From: Anita Gardner
Sent: 07 January 2019 09:54
To: Planning.Responses
Subject: FW: FG/171/18/DOC - Peugeot Garage Premises, Littlehampton Road,
Attachments: 17036 - Construction Management Plan (RevC).pdf

Environmental Health: Application for discharge of conditions. Further information required.

Honda Worthing 11-07-18 EXT REV 0

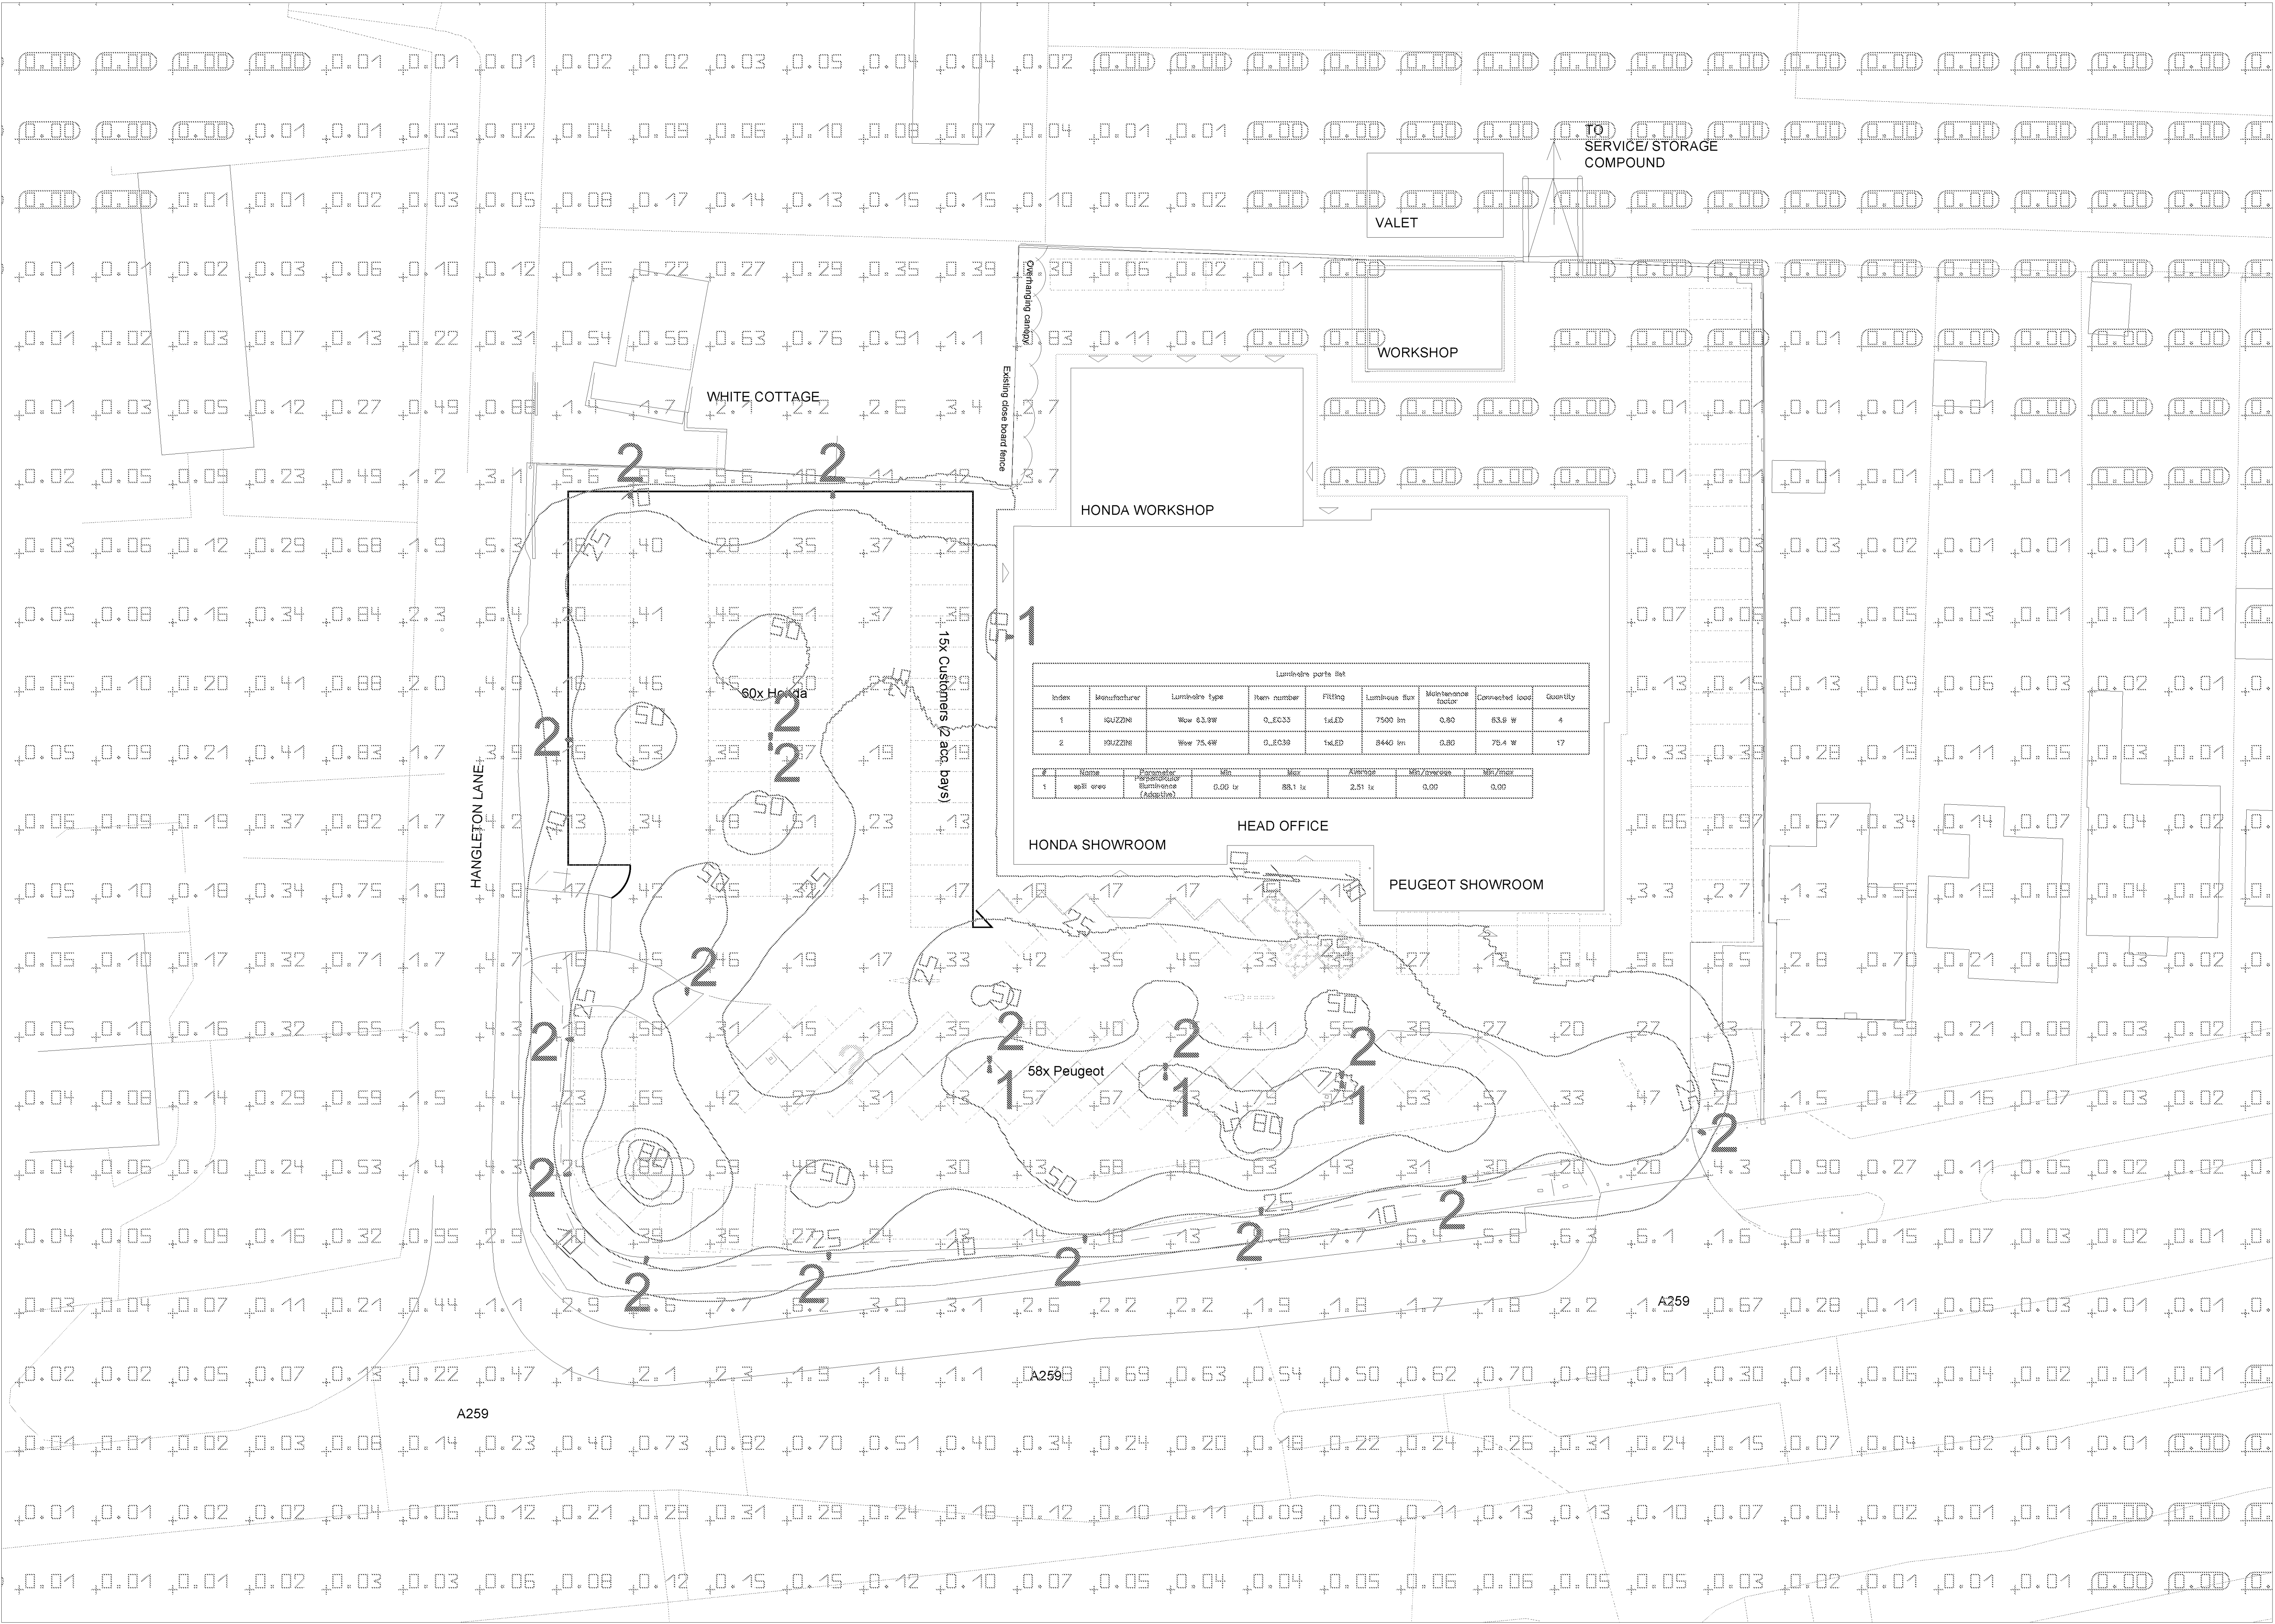
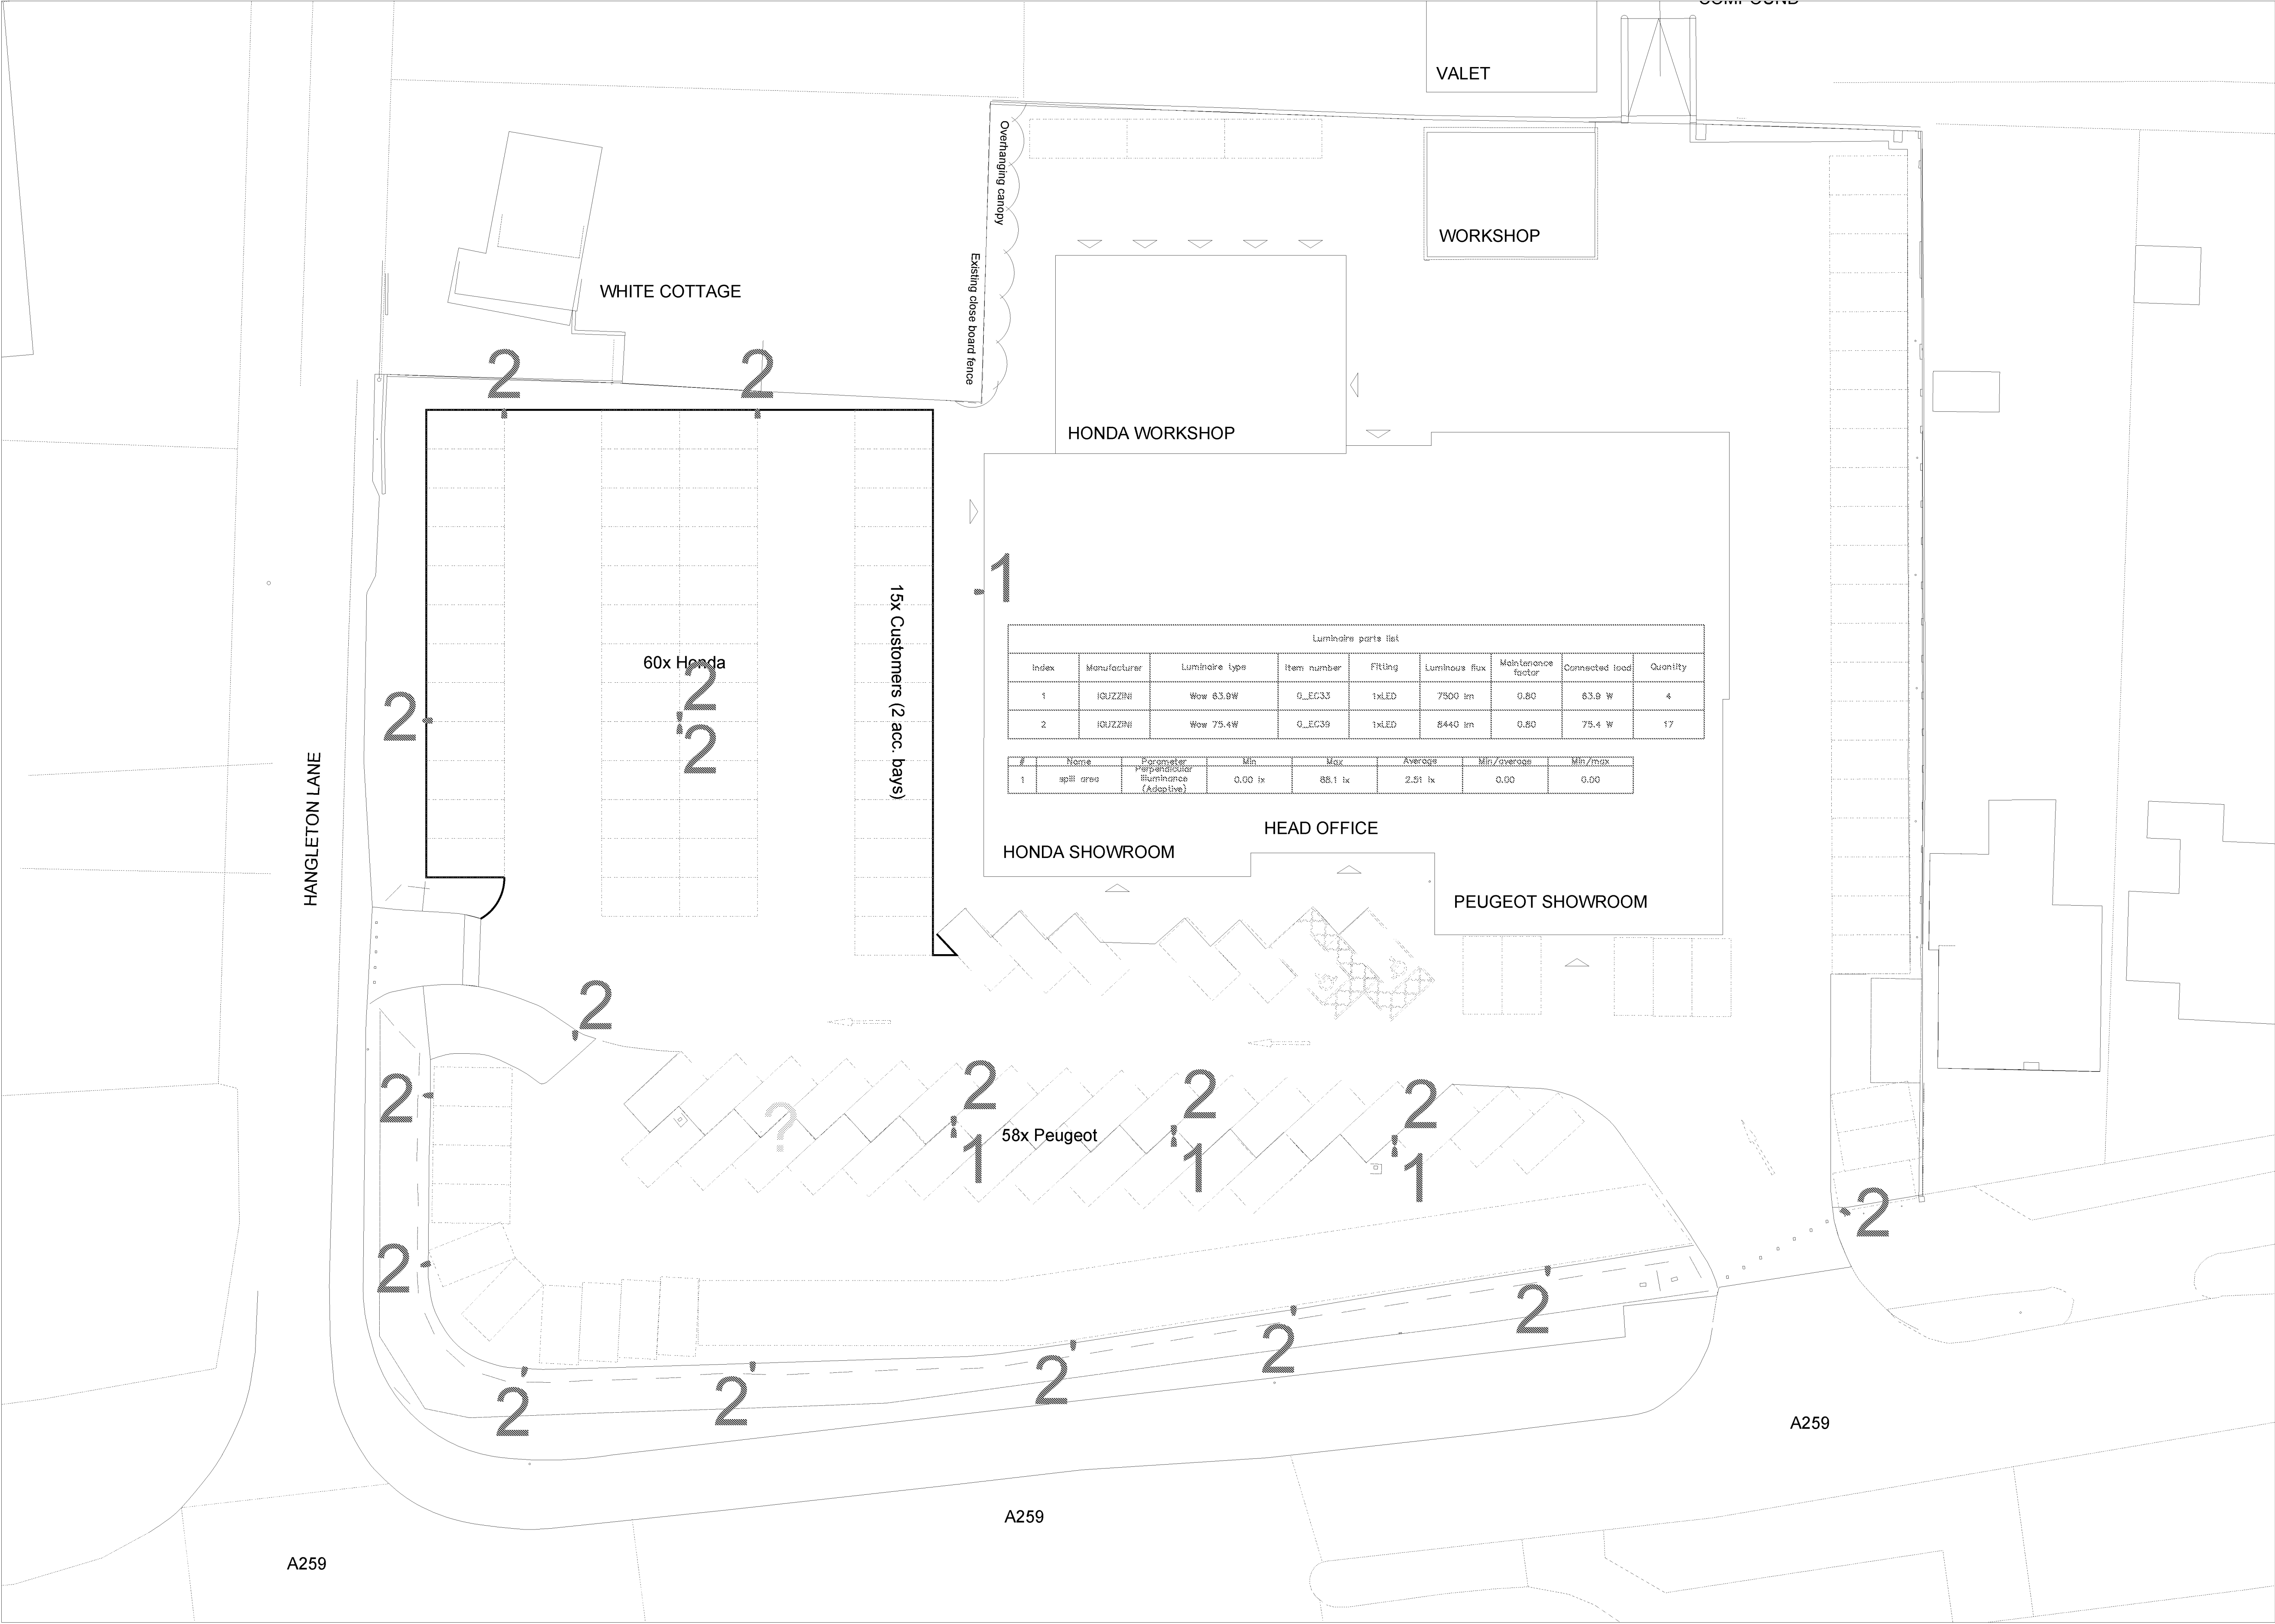
Lighting Plan: Lower level lighting, specified as 'Type 1' to be provided to areas proximal to sensitive receptors and to the north of the site in order to prevent detriment to the amenity of these properties and South Downs National Park.

I understand that our electrical engineer will contact the EH officer on her return from leave on Monday to discuss the external lighting design comments further. Hopefully to a resolution asap.
